**DEVELOPMENT REVIEW BOARD (DRB)
CITY OF ALBUQUERQUE**

REVIEW COMMENTS

D.R.B. CASE NO.: 002737 DATE: 6/25/03 ITEM NO.: 19
ZONE ATLAS PAGE: H-13 LOCATION: Rio Grande
Los Arroyos
REQUEST FOR: Sketch Plat

Project Name: MRGCD Map #35, Tract 55

**PLAT OF
TRACT 55
M.R.G.C.D. MAP No. 35**
ALBUQUERQUE, NEW MEXICO
MAY, 2003

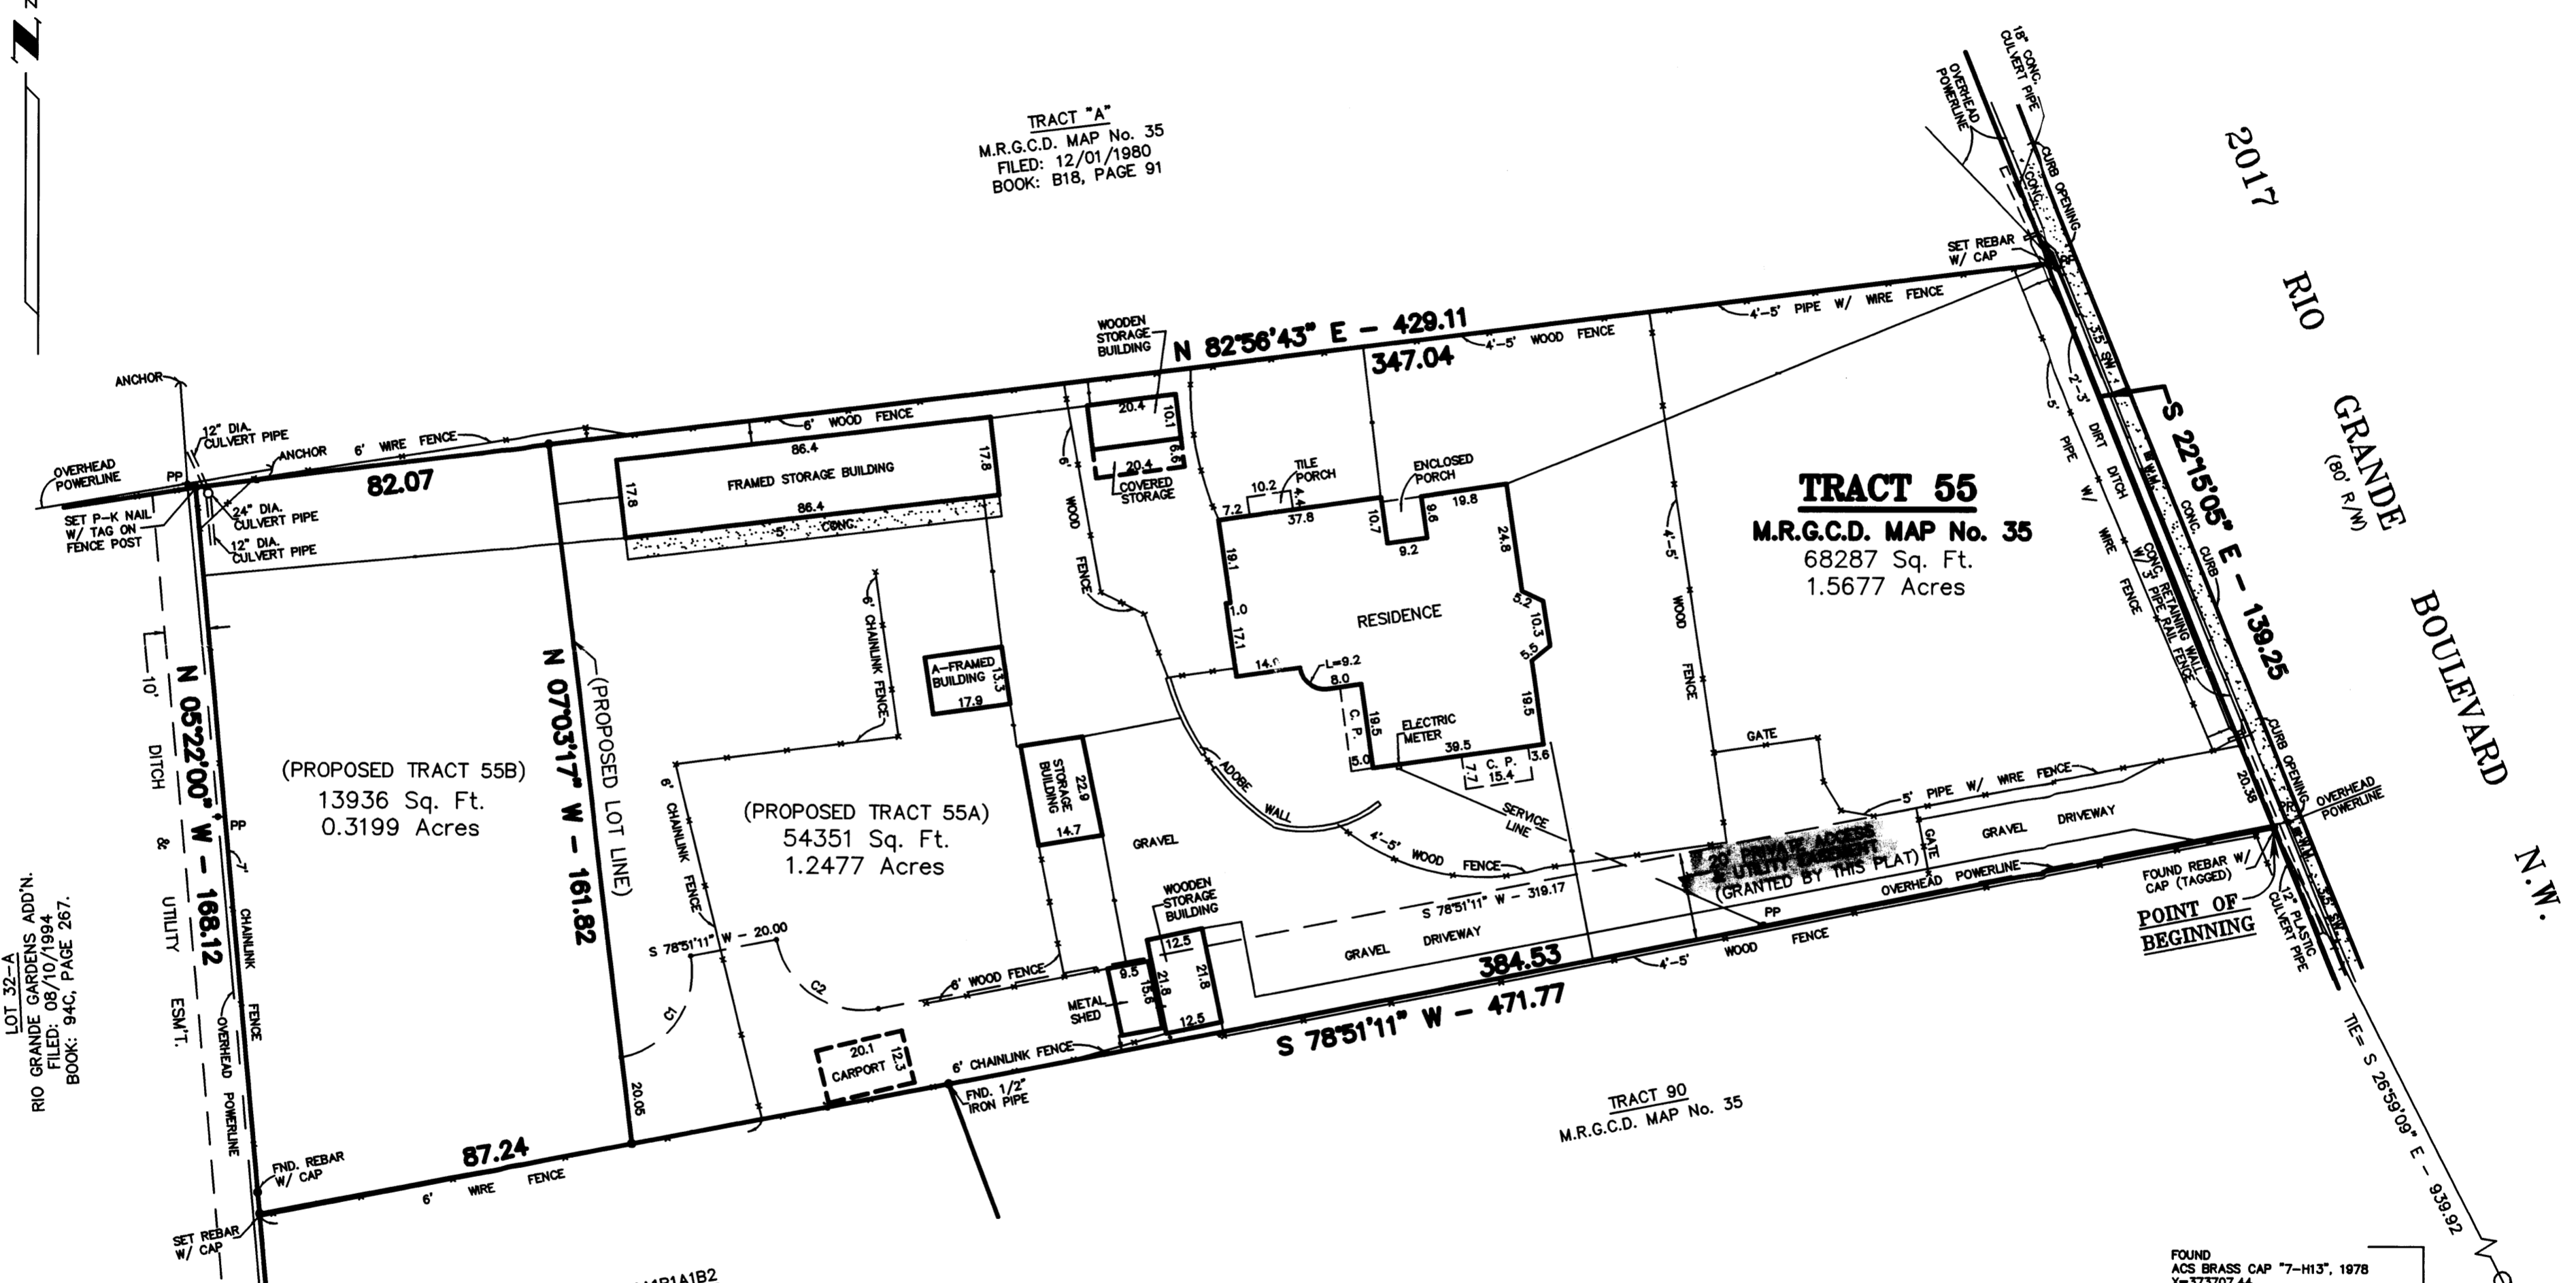
① Need a Fire Hydrant within 450' of rear lot.
This must be installed at Owner's expense.

② Need to dedicate private Water/Sewer service
easement and provide beneficiary & maintenance
statement.

How will the new tract get access to Rio Grande Boulevard?
